Car Parking:

171204 Smalls Rd SSD Submission		
Owner: Parks and Recreation	Author: Carolyn Becker	Version: 1.2
Trim Reference:	Date: Friday, 15 December 2017 10:10 AM	Page 1 of 3
File Location: C:\Users\carolynb\AppData\Local\Microsoft\Windows\Temporary Internet Files\Content.Outlook\ID7057A6P\171204 Smalls Rd SSD Submission.docx

Sheet Subject
**DROP-OFF AND PICK-UP BAY
 PROPOSED RESTRICTIONS
 SIGNAGE PLAN**

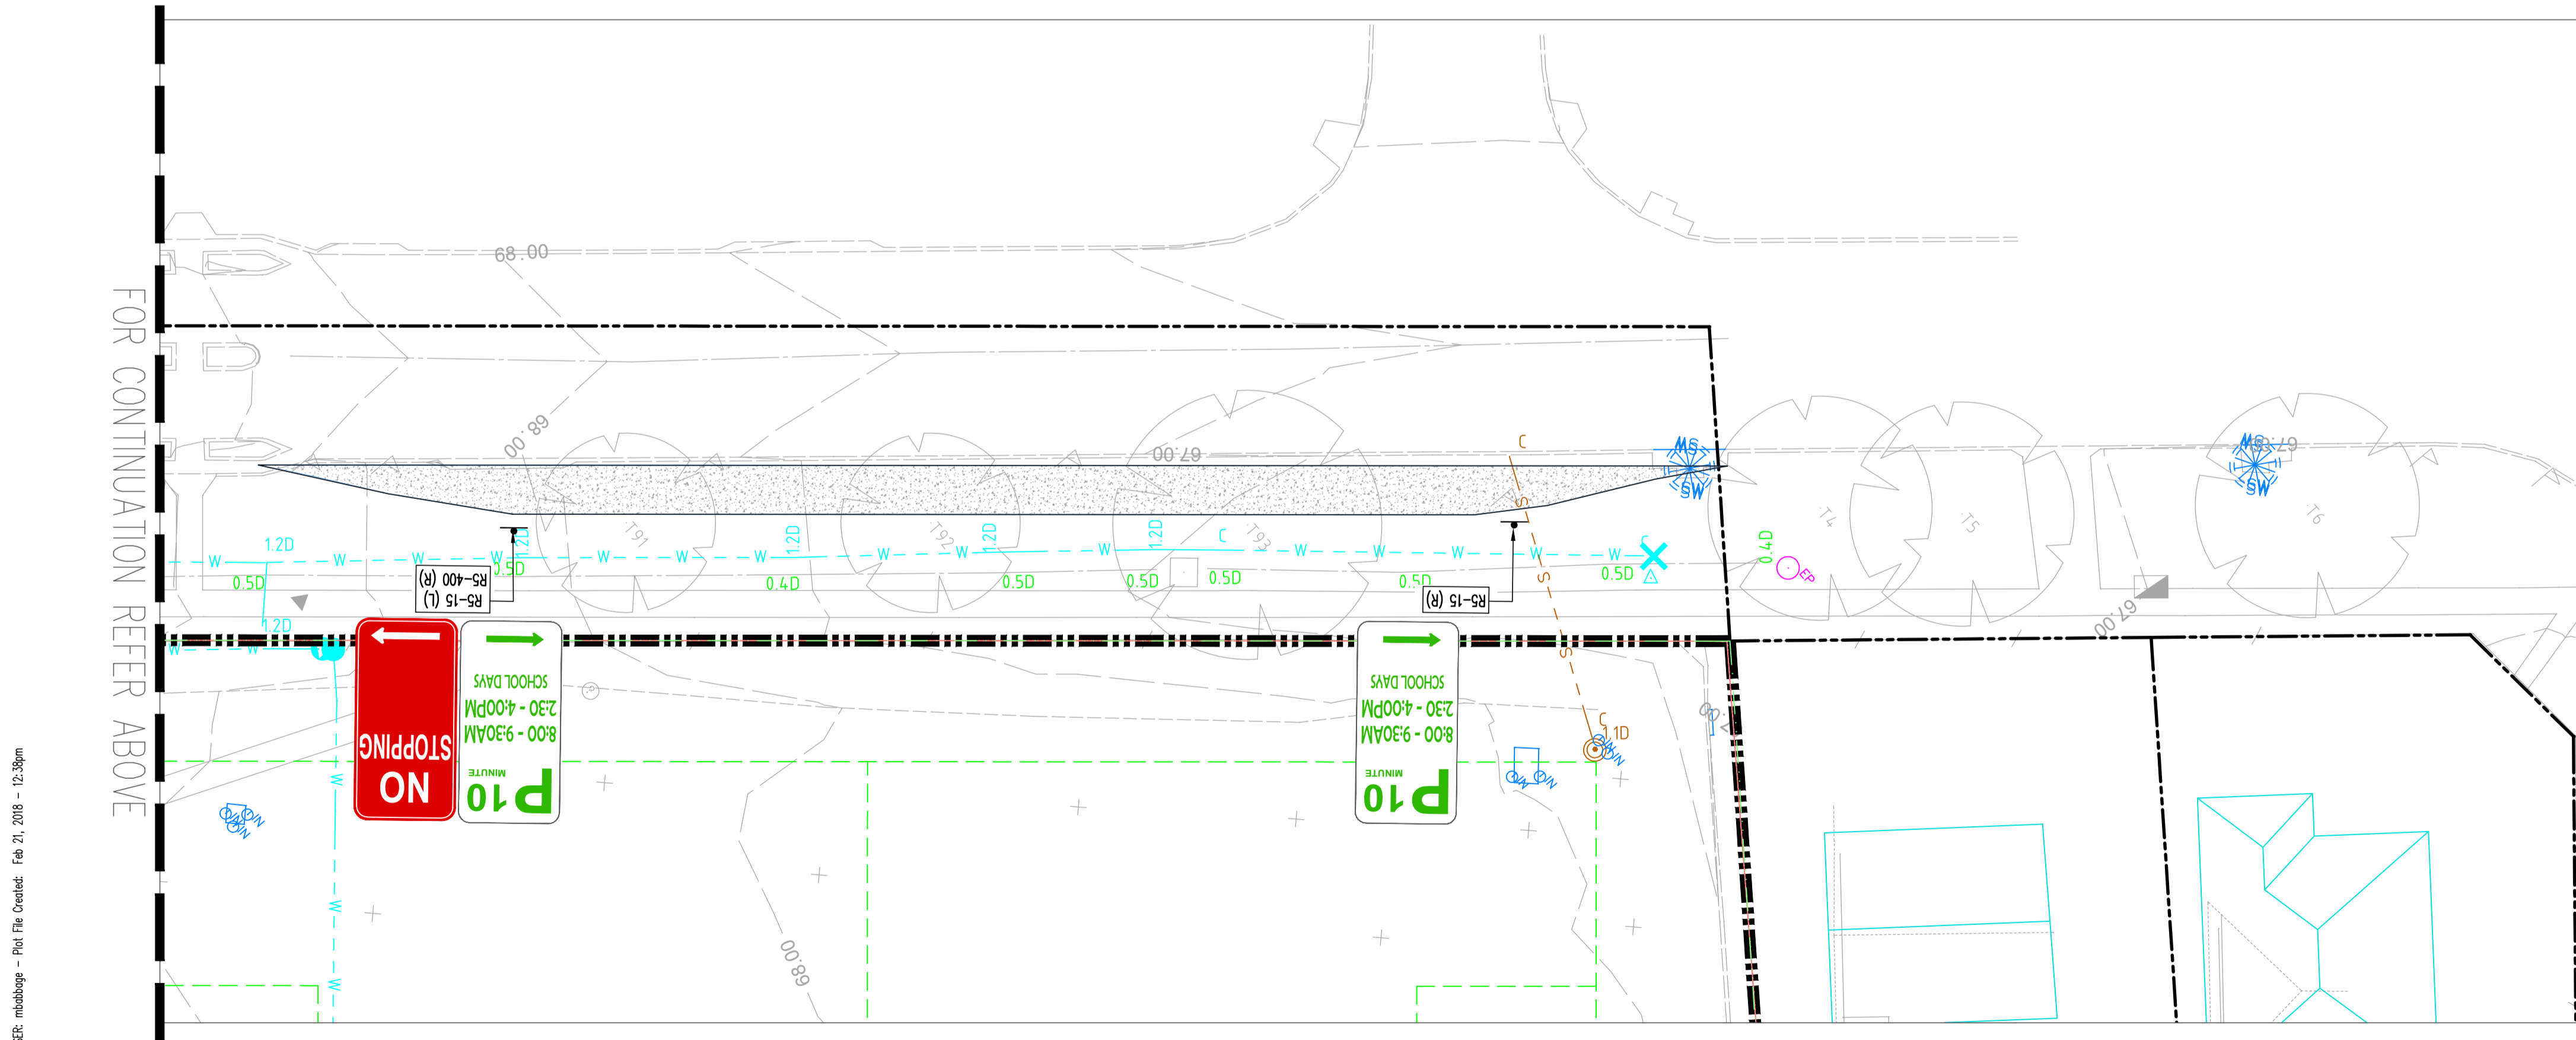
- The proposal suggests that a 16 car Kiss and Ride/No Parking zone and 10 car P10/P15 zone should accommodate the parking needs of parents and carers of children attending the school. Site observations at similar schools in the Ryde LGA indicate that the 90 second turnaround time associated with the proposed drop off/pick-up on-street zone is not realistic and does not reflect the fact that many parents would walk their children to the gates of the school. Change in parking conditions will require approval by Ryde Traffic Committee.

- A covered area for students to wait is required at locations that are designated drop off/pick up zones.
- Indented parking areas are provided along southern side of Smalls Road, which is not sufficient to cater for demand generated by 1000 students. Kiss and Ride/No Parking zone should be provided along northern side of Smalls Road. Thus widening of Smalls Road is required along the full length of the proposed school frontage to accommodate:

- o Kiss and Ride/No Parking on northern side of Smalls Road
 - o 2-way traffic flows
 - o Indented Kiss and Ride/No Parking and P10/P15 zones on southern side of Smalls Road.

SITE STORMWATER PLAN

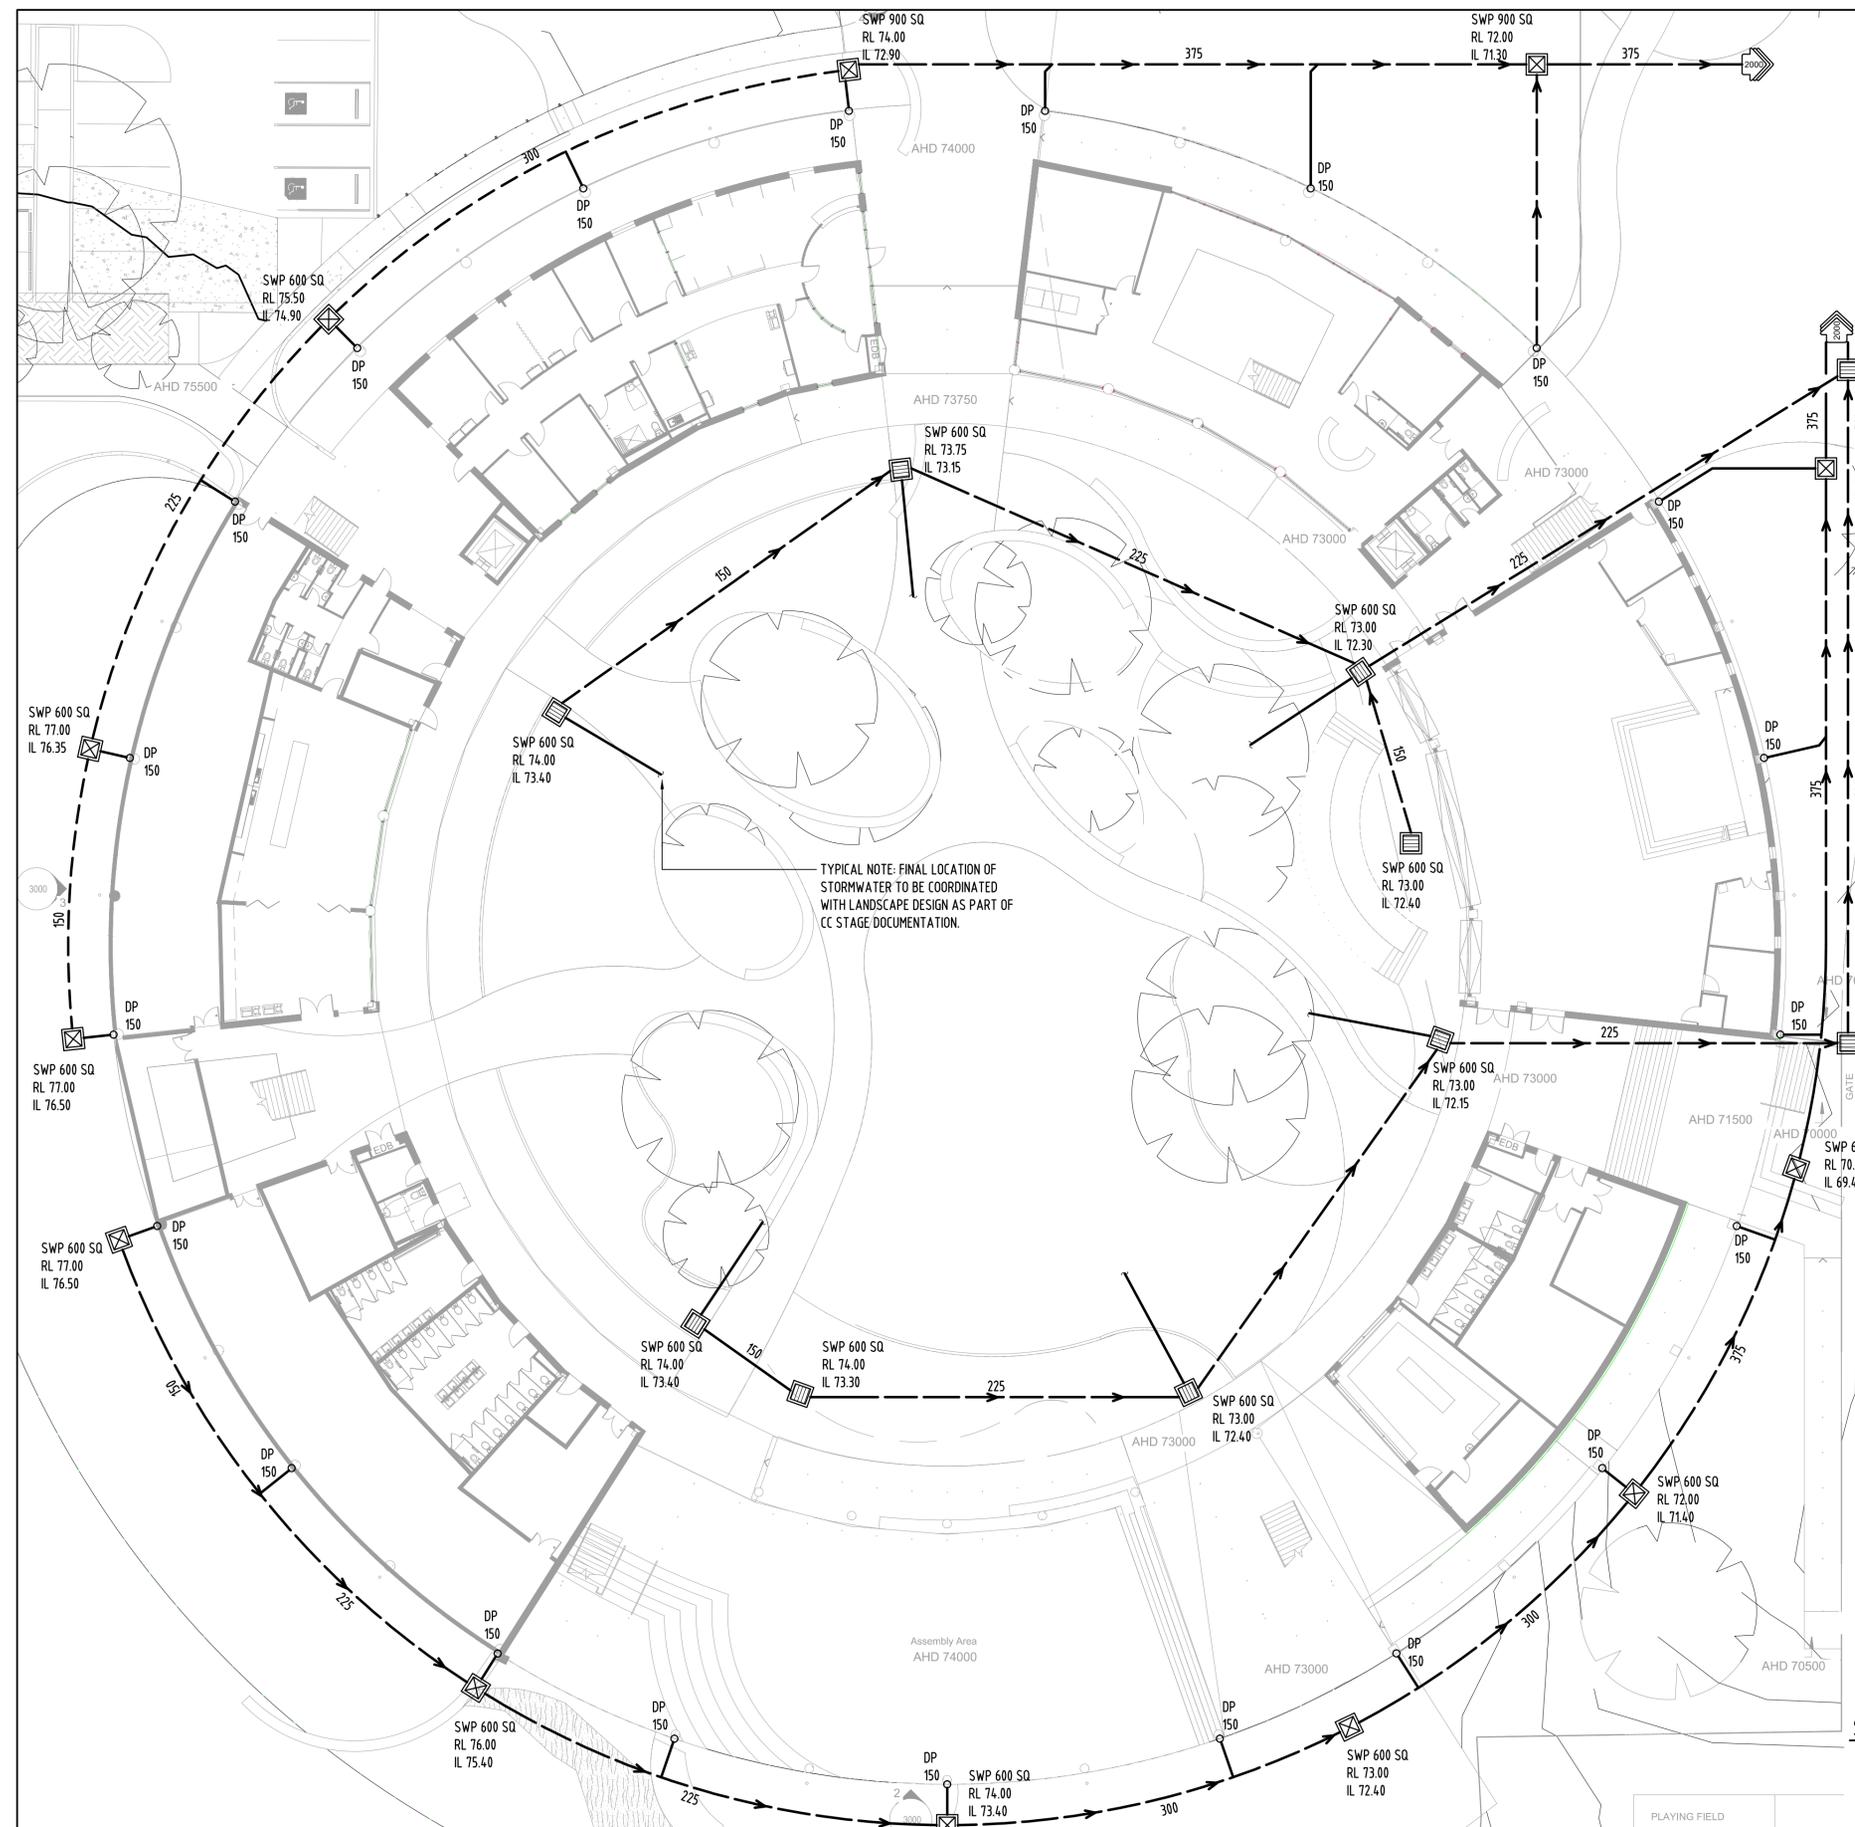
- According to Council's GIS mapping system, the existing properties along Lavarack Street that backs on to the proposed school site on Smalls Road have a natural fall to the rear. As a result the subject properties are unable to access Council's street drainage system on Lavarack Street.

- There have been ongoing concerns from the residents on Lavarack street regarding the lack of underground drainage system along the rear fence of these properties. Installation of an underground drainage pipeline along the eastern boundary of the proposed school site will provide the subject residents access to Council's existing drainage line along the Northern boundary of the proposed school site.

- Furthermore, this will also help in safely conveying stormwater runoff from the subject properties away from any proposed school buildings. It is recommended that a new drainage line as per the attached plans be installed in order to manage the stormwater runoff coming from the subject properties along the eastern boundary of the proposed school site. A schematic has been provided for the location of a new stormwater pipeline which can be constructed to help improve the stormwater system in the school as well as the properties on Lavarack Street.
